Please ask for: Nicola Moore
Email: nicola.moore@arun.gov.uk
Telephone: Ext 37944
Our Ref: BN/47/21/CLP
Your Ref:
Date: 26th April 2021

Lawful Development Certificate for a Proposed Use or Development

Development: Lawful development certificate for a proposed rear timber frame and face brick extension and re-roofing if conservatory with plain clay tile.
Location: Barncroft Wandleys Lane Fontwell PO20 3SE

PROPOSED GROUND FLOOR PLAN &
ROOF PLAN

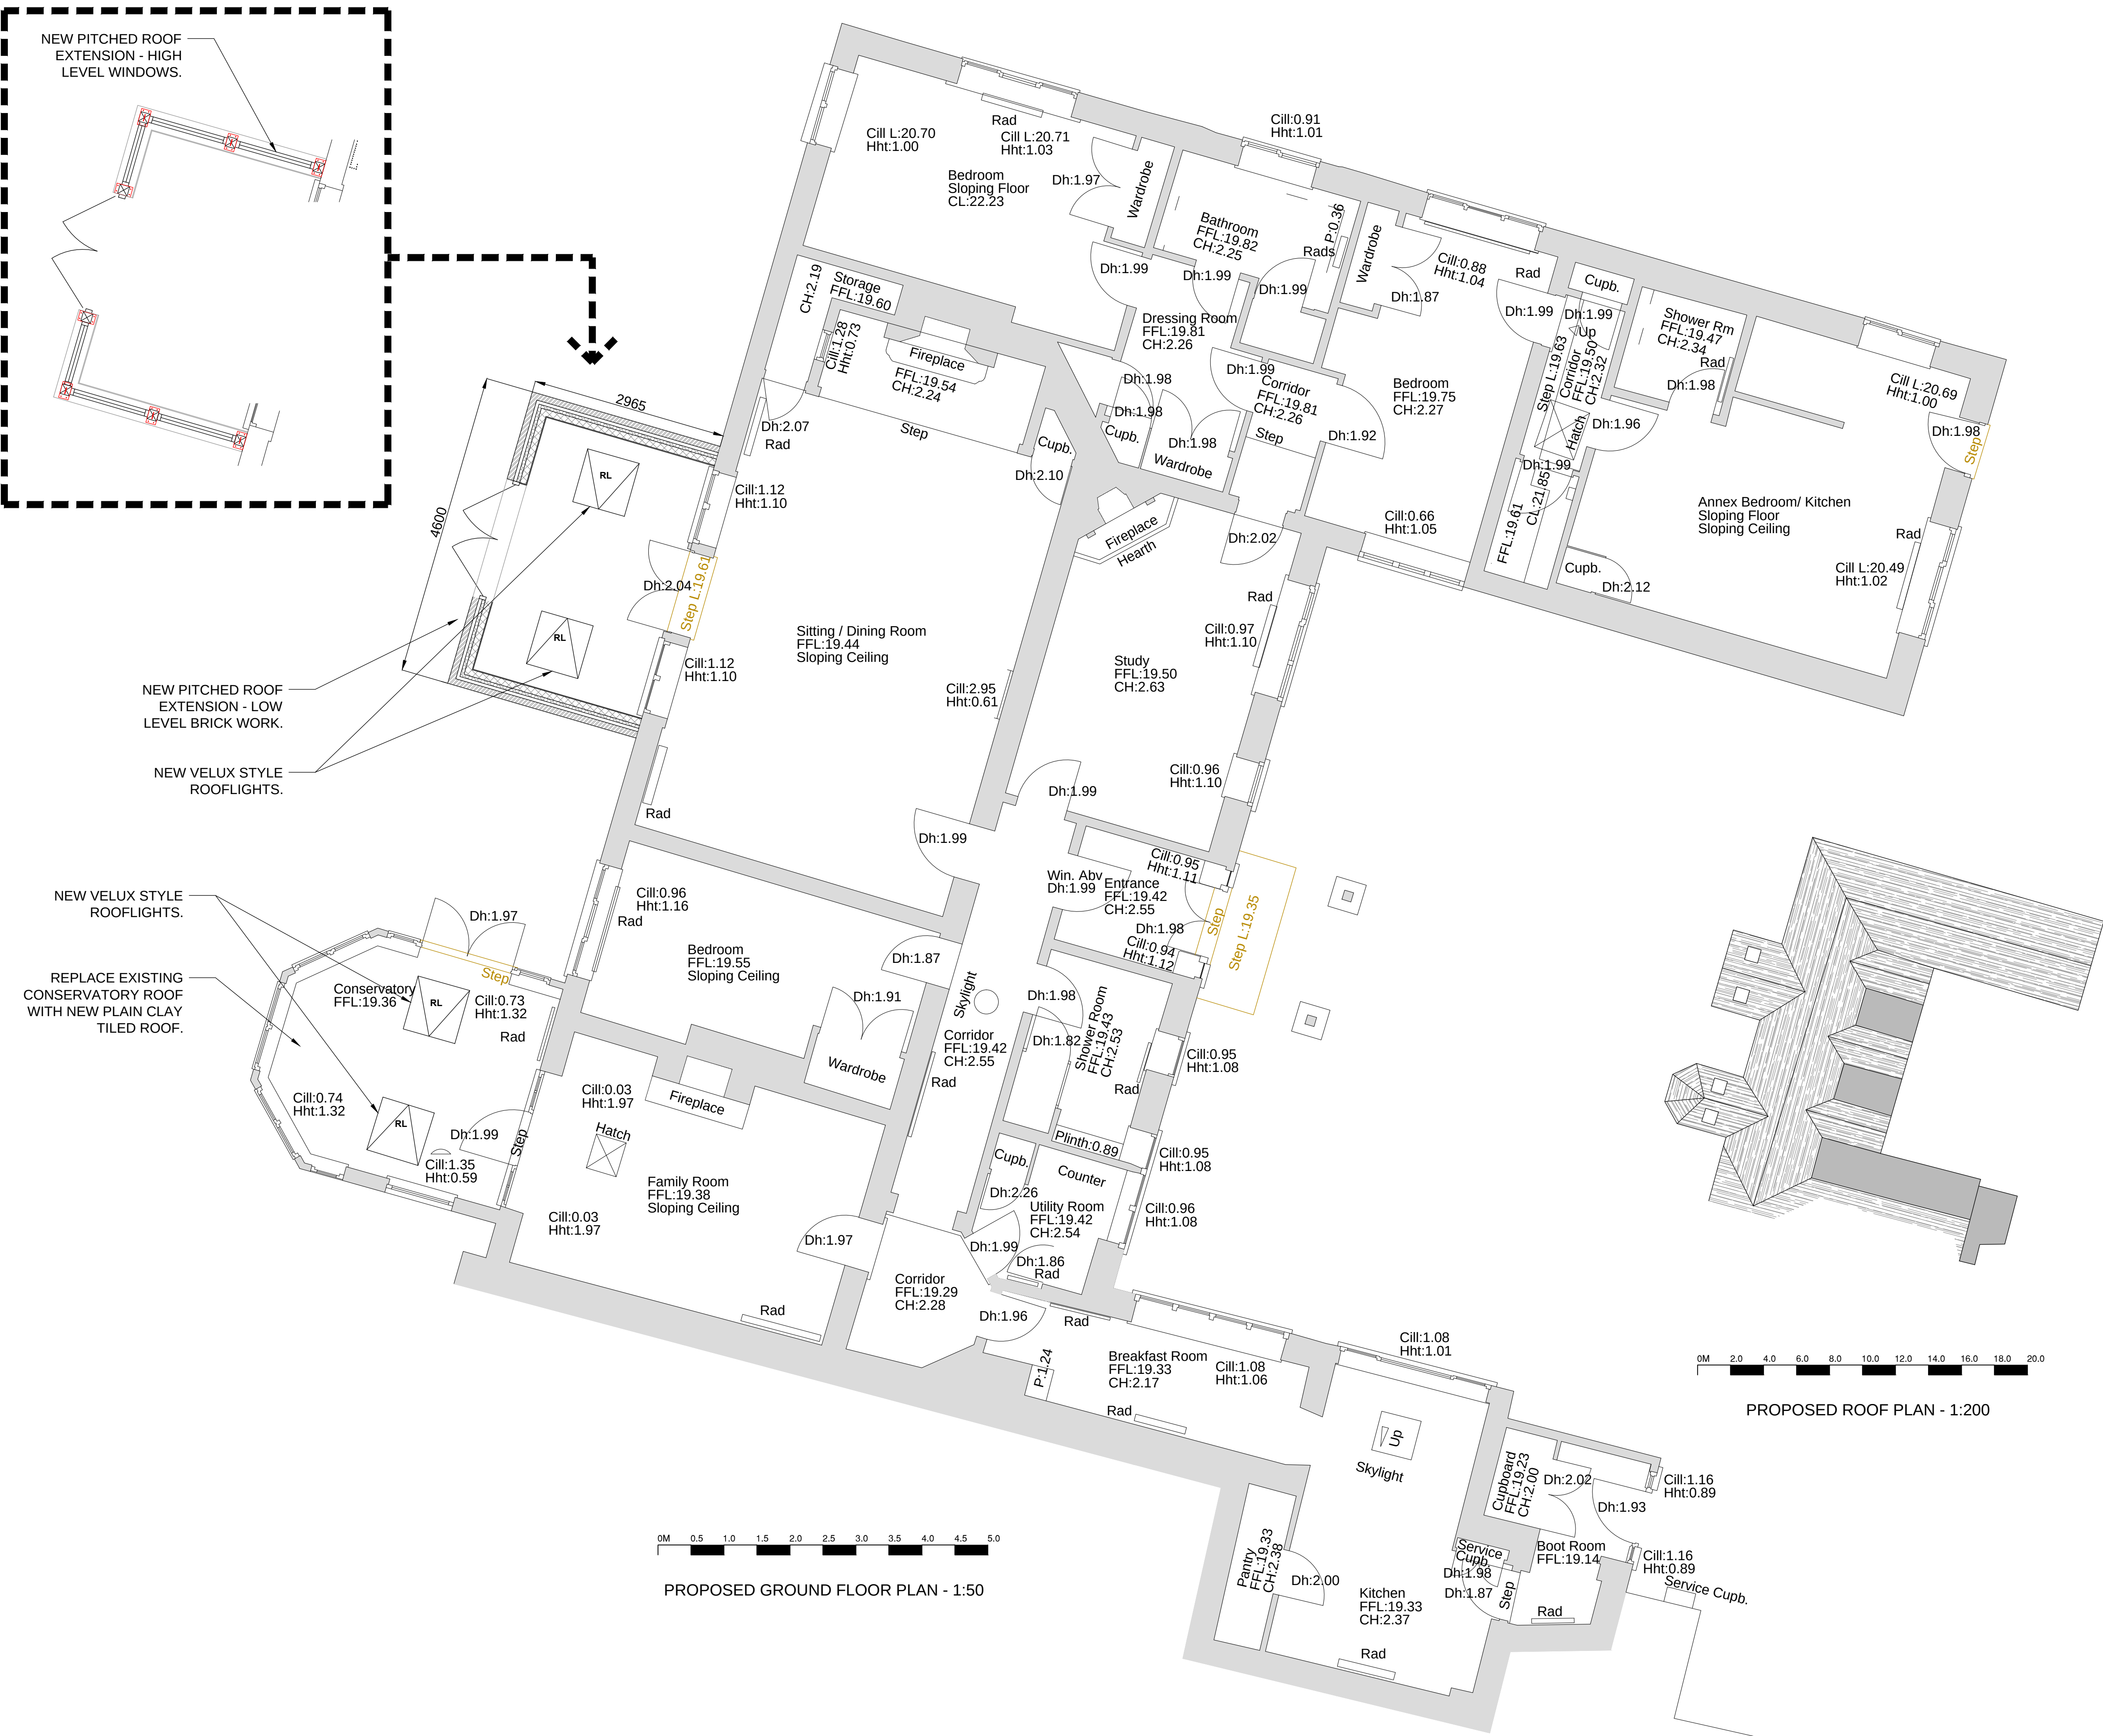
The Proposed Floor Plan does not scale correctly at 1:200, please amend accordingly and re submit.
